**PLANNING ACT 2008
APPLICATION BY HIGHWAYS ENGLAND FOR AN ORDER GRANTING
DEVELOPMENT CONSENT FOR THE A303 SPARKFORD TO ILCHESTER
DUALLING
SUBMISSION MADE PURSUANT TO DEADLINE 6**

PLANNING INSPECTORATE REFERENCE TR010036

SUBMISSION MADE PURSUANT TO DEADLINE 6a

Somerset County Council Response to Deadline 6a: - The Examining Authority's written questions and requests for information (ExQ3) Issued on 25 April 2019

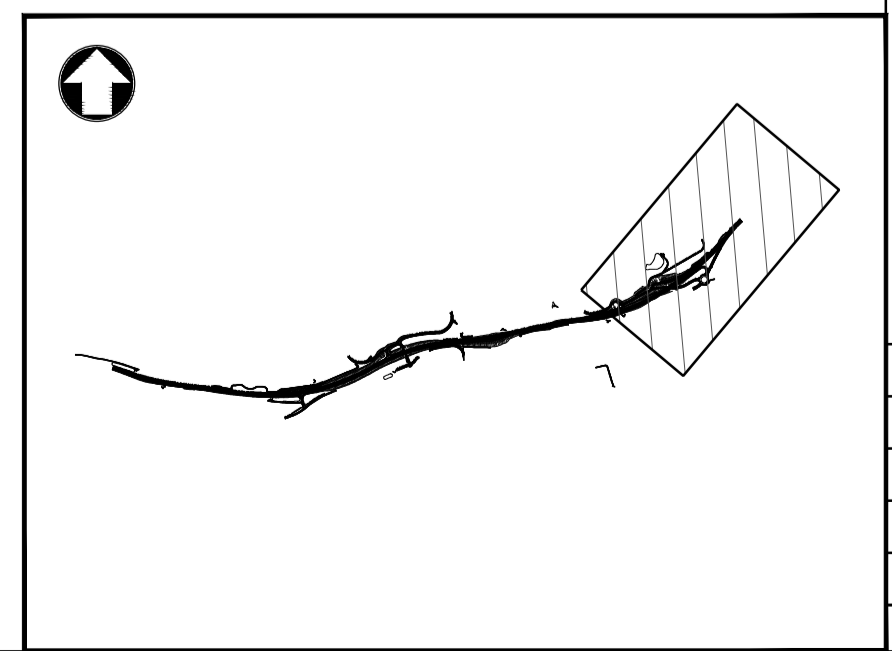
3.0.12	<p>Scheme Lighting</p> <p>Within the draft Statement of Common Ground between the Applicant, SCC and SSDC [REP5-017], SCC comments on the responsibility of the proposed lighting system. The Applicant states that this is a matter of detailed design.</p> <p>It is unclear why this should be a matter of detailed design. What mechanism is in place to address this detail?</p>	<p>The preliminary scheme design provides an outline of the highway lighting design. Only on completion of the detailed design can the location of the highway lighting infrastructure and associated energy supply network be determined and the maintaining authority confirmed.</p> <p>SCC seek provision within the DCO to be the approving authority on all matters of detail where they relate to the local road network. Highway lighting should form one of those matters of detail. As such, SCC has included "road lighting (including columns and brackets)" in the definition of "Detailed Information" to be provided to the Local Highway Authority pursuant to its proposed Protective Provisions.</p>

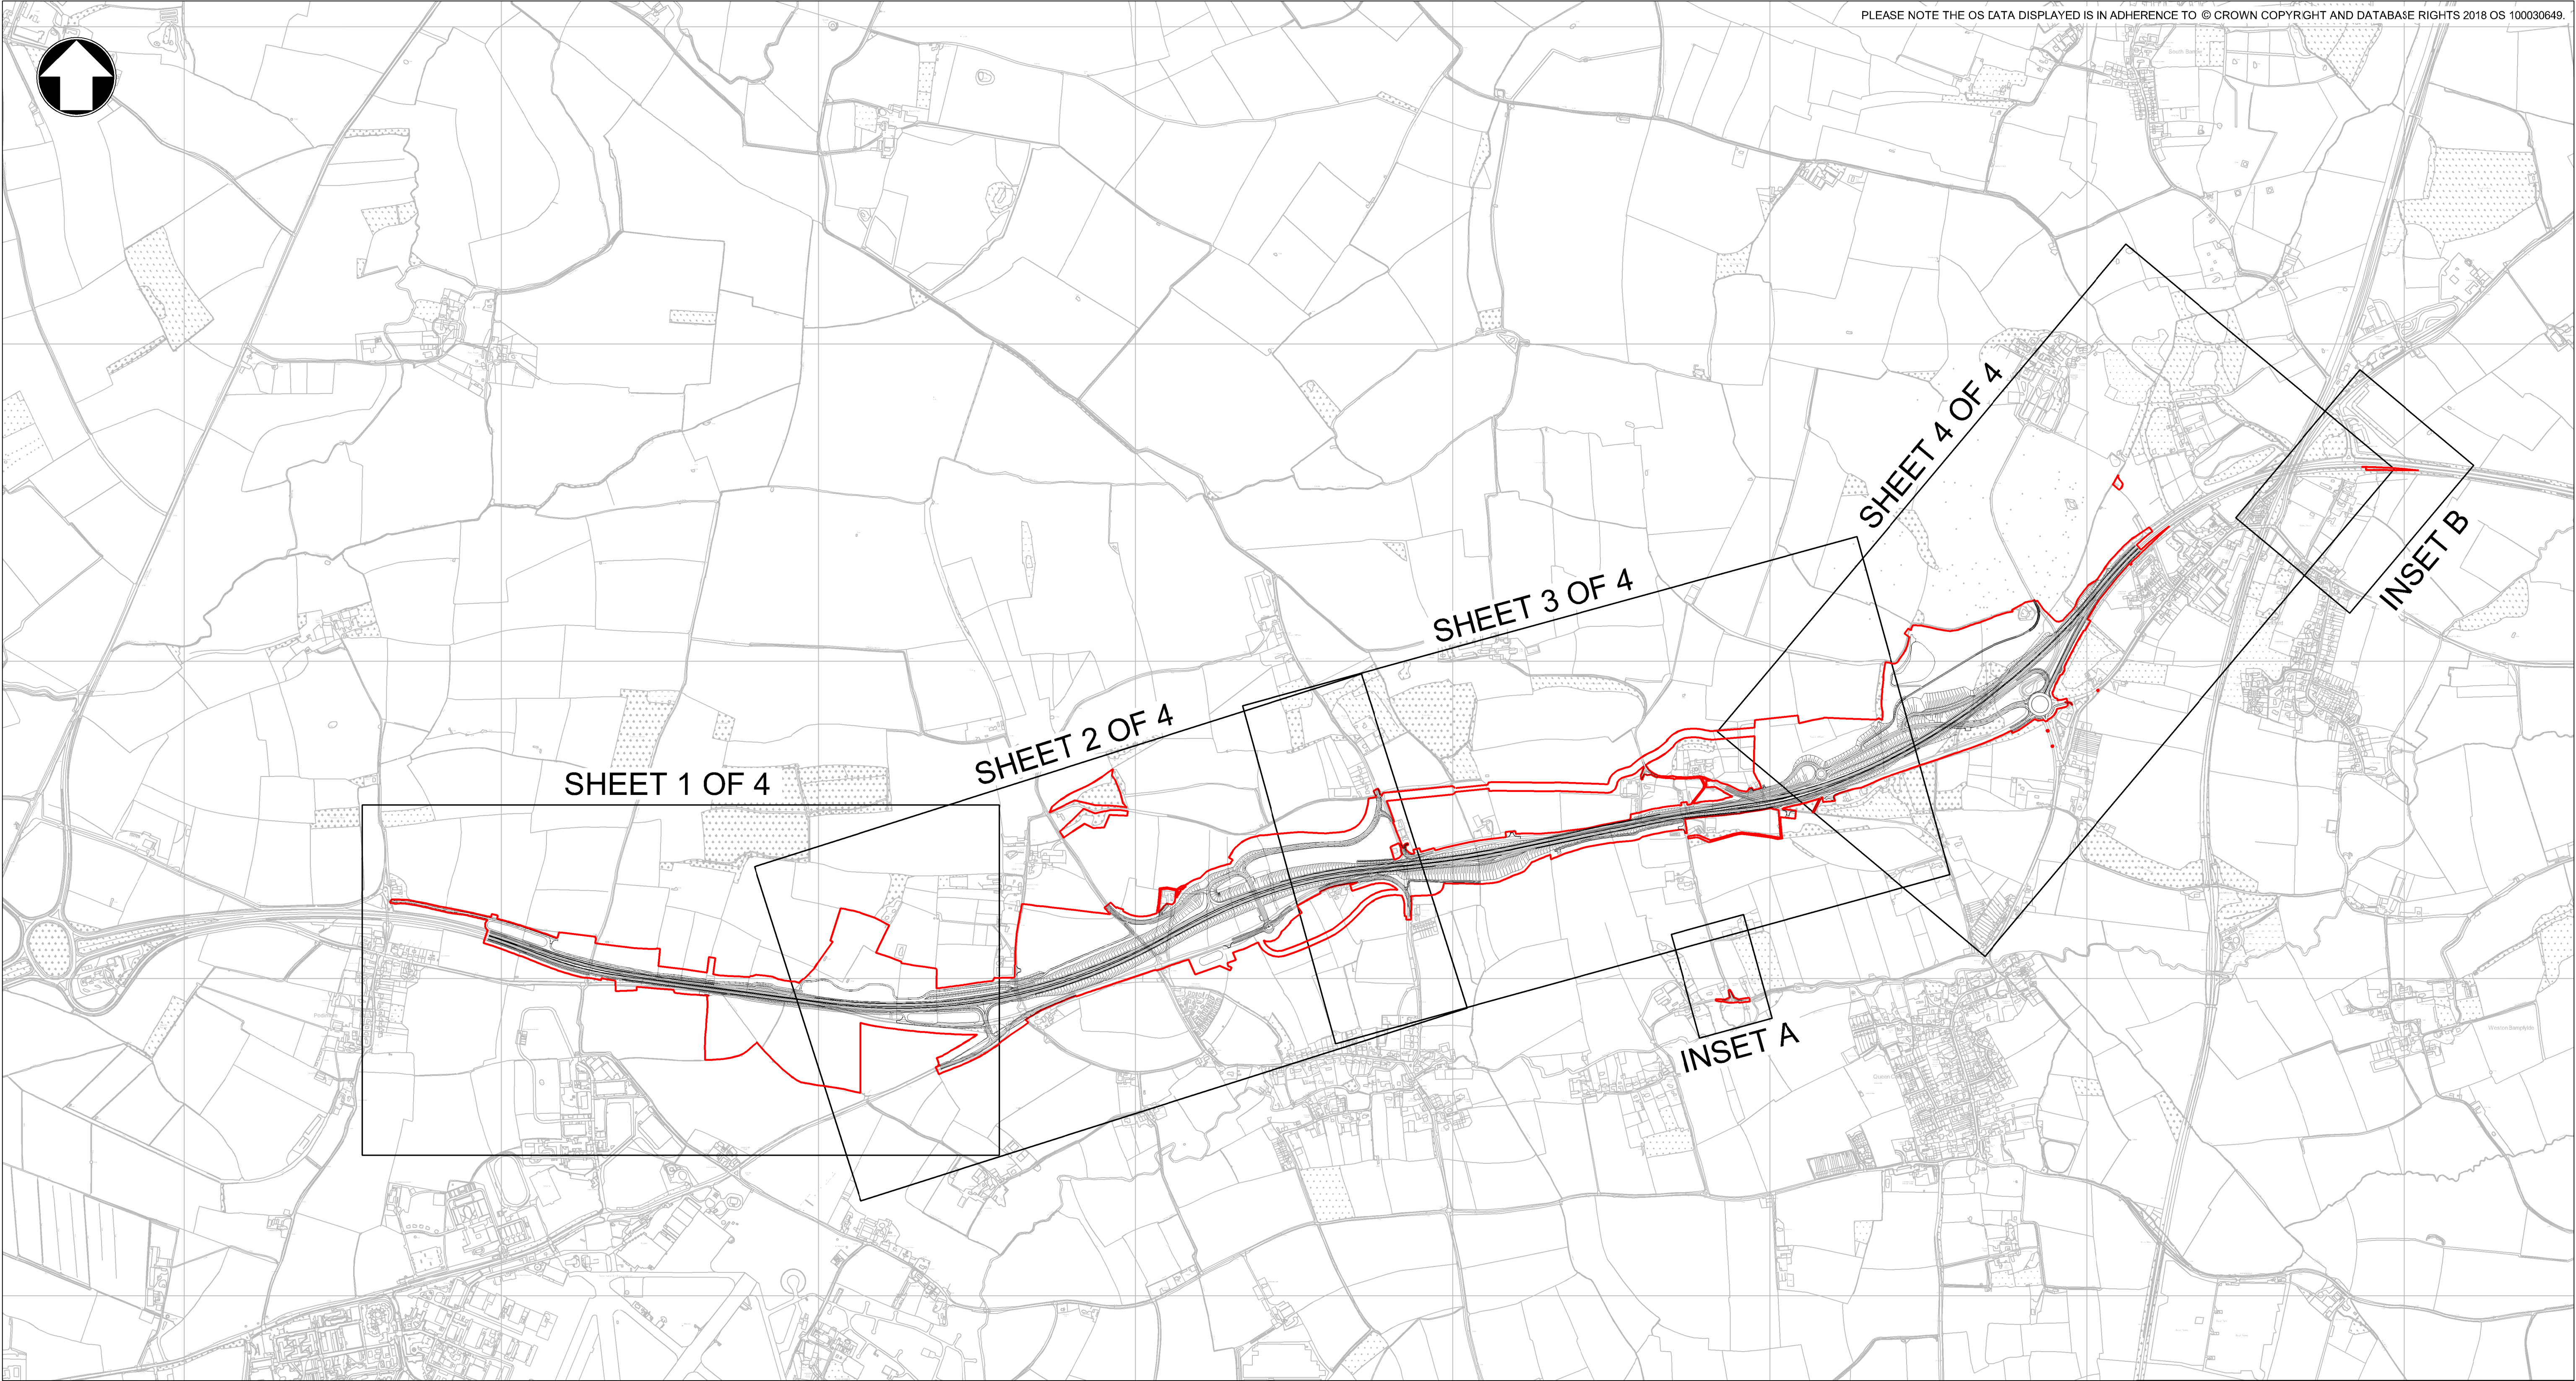
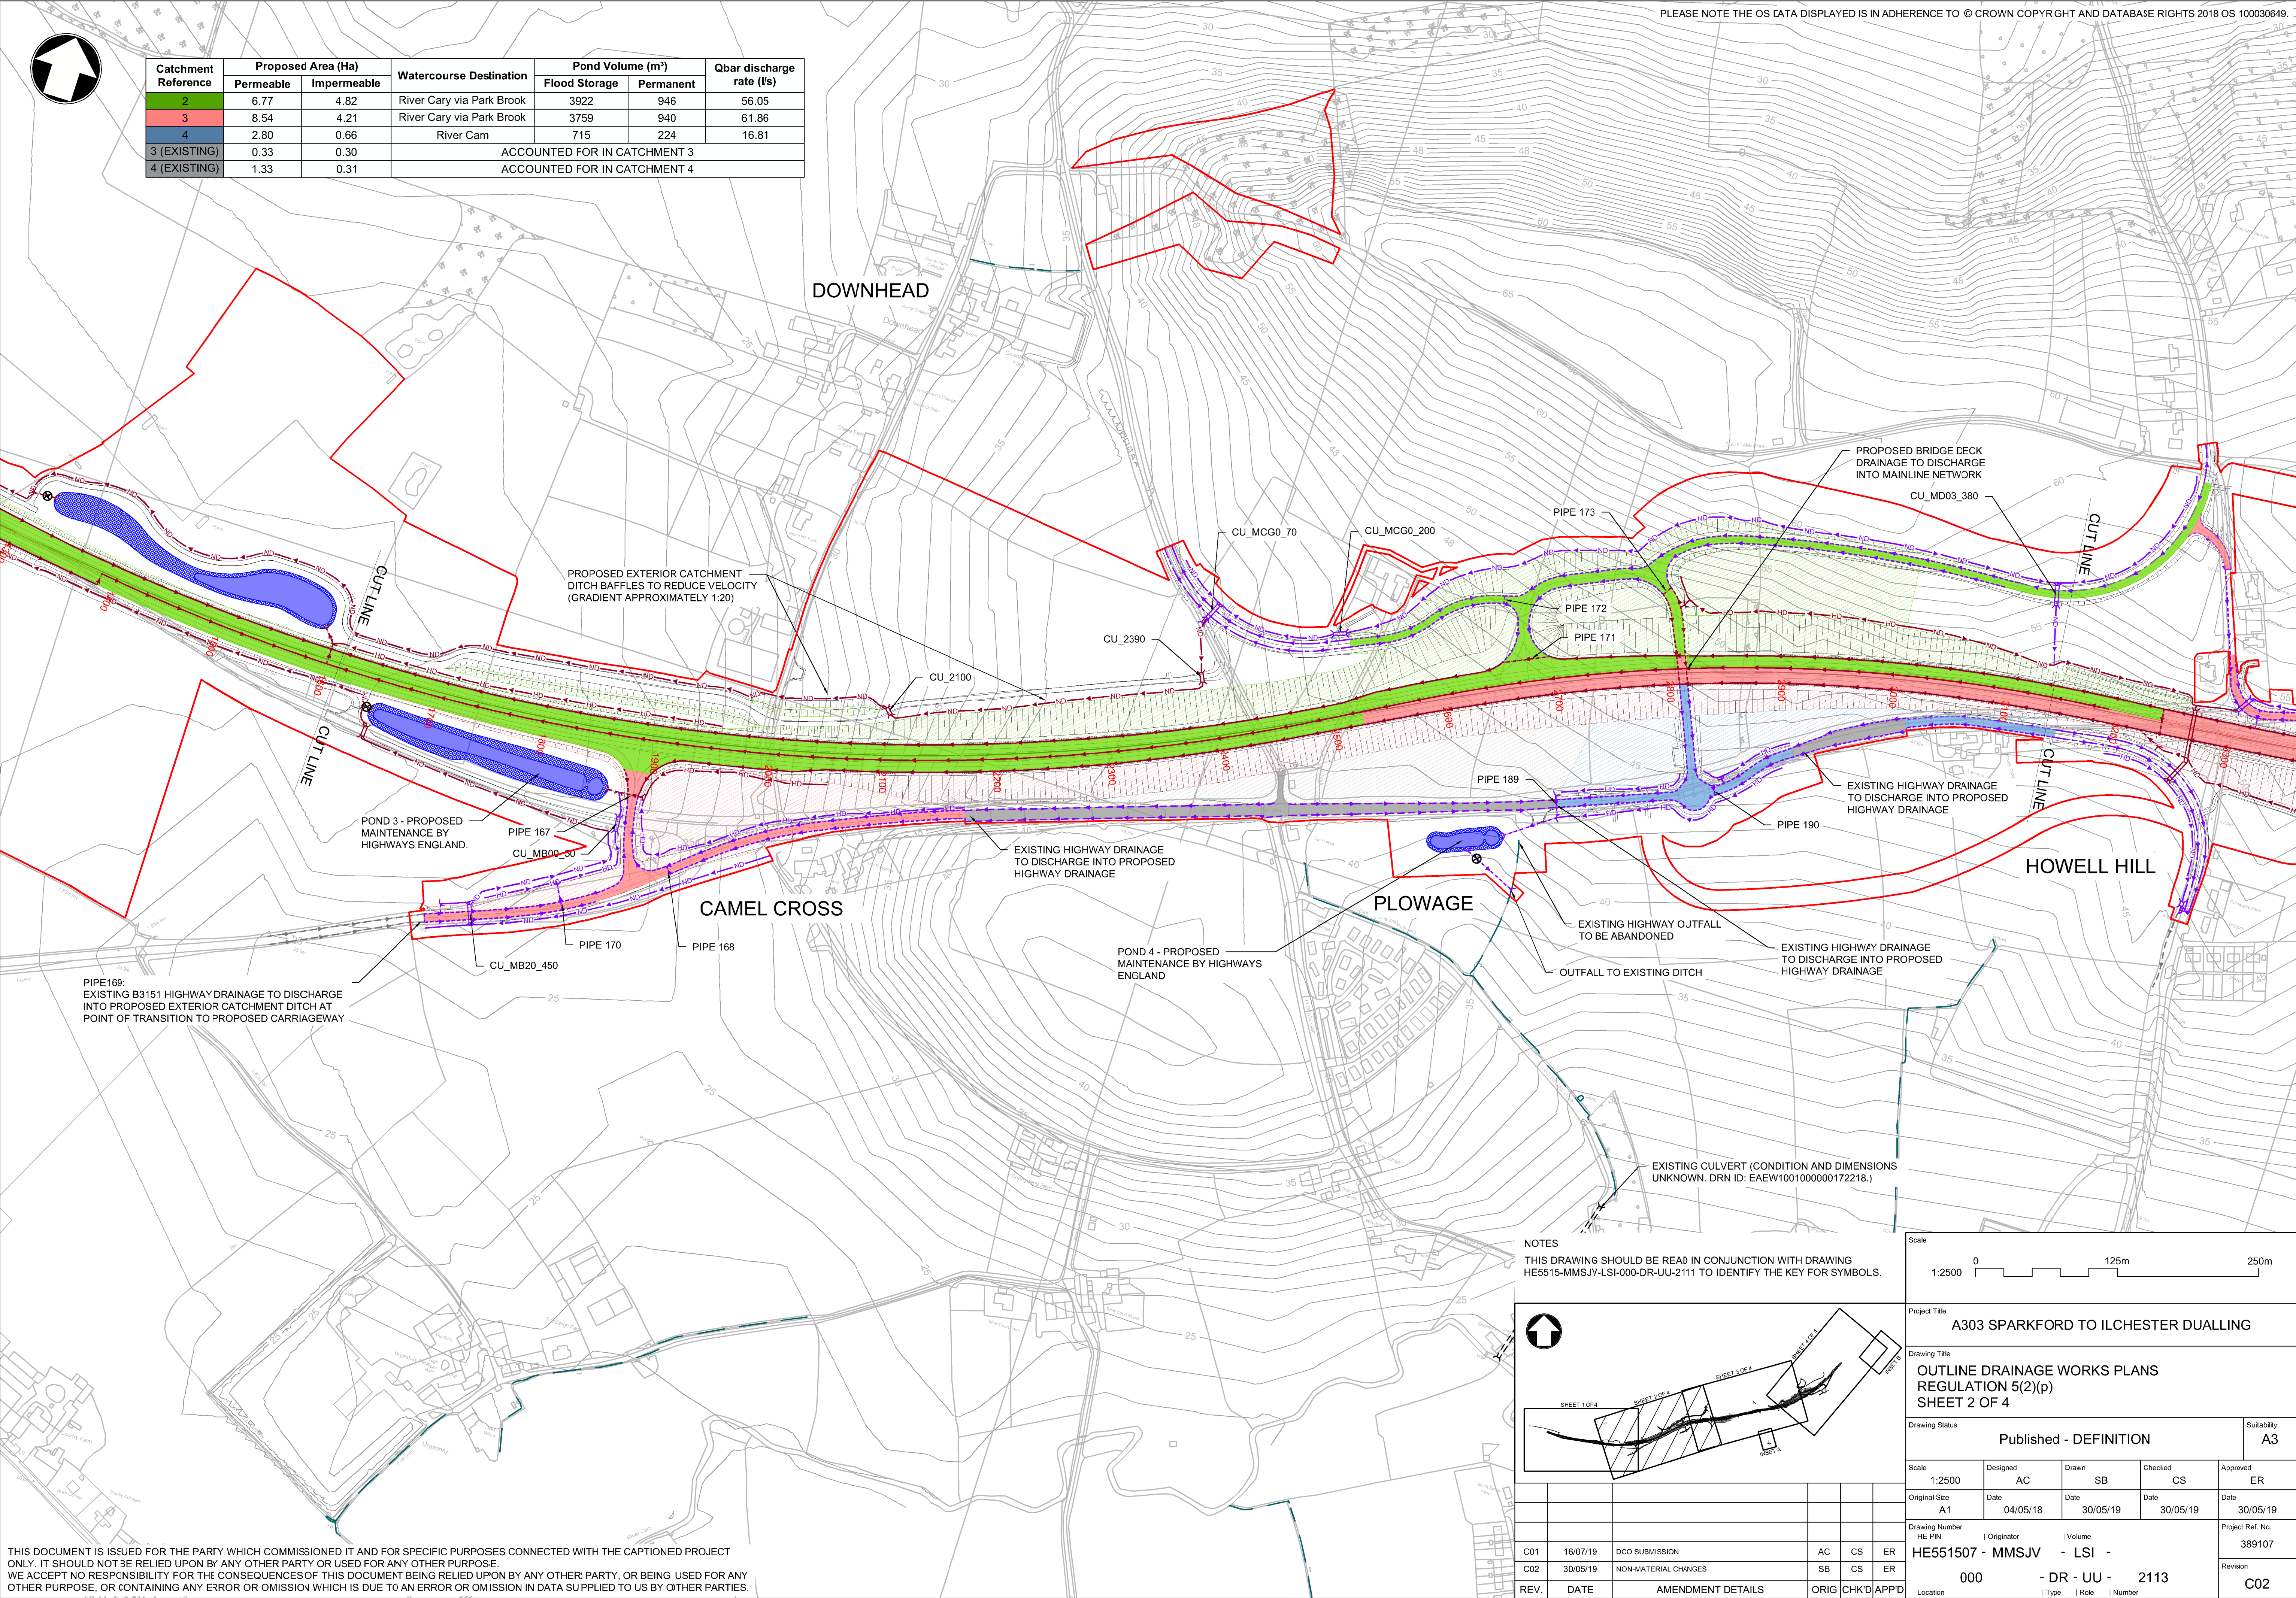
3.10.17	<p>Schedule 2 - Requirement 13 Surface Water Drainage</p> <p>While the dDCO limits the relevant discharge rates, it does not provide for the maintenance of the Sustainable Drainage Systems (SuDS) schemes. Therefore, it could</p>	a) SCC agrees that a maintenance regime would need to be secured. Appendix 4.7 (Drainage Strategy Report) of the Environmental Statement dated July 2018 does set out an indicative maintenance regime within Tables 7.1;

ExA Q Ref	Question	SCC Response
	<p>lead to excessive water retention on the site with unassessed effects. By ensuring that the SuDS schemes are managed and maintained this avoids this issue.</p> <p>a) Therefore, is a scheme for the management including maintenance of the SuDS schemes to ensure long-term effective operation required?</p> <p>b) Should be this scheme for the approval of the Local Lead Flood Authority as this this is the statutory authority and thus would be the appropriate level for authorisation?</p>	<p>Table 7.2; and Table 7.3. However, it's not clear how maintenance is then actually secured within the DCO.</p> <p>When being consulted on Town and Country Planning Act applications, SCC as the Lead Local Flood Authority will seek individual planning conditions to secure the submission, approval and implementation of maintenance arrangements, where relevant. SCC will be able to provide draft wording at the relevant Issue Specific Hearing.</p> <p>b) SCC advises that the scheme is submitted to the Local Planning Authority for approval in consultation with the Lead Local Flood Authority.</p>
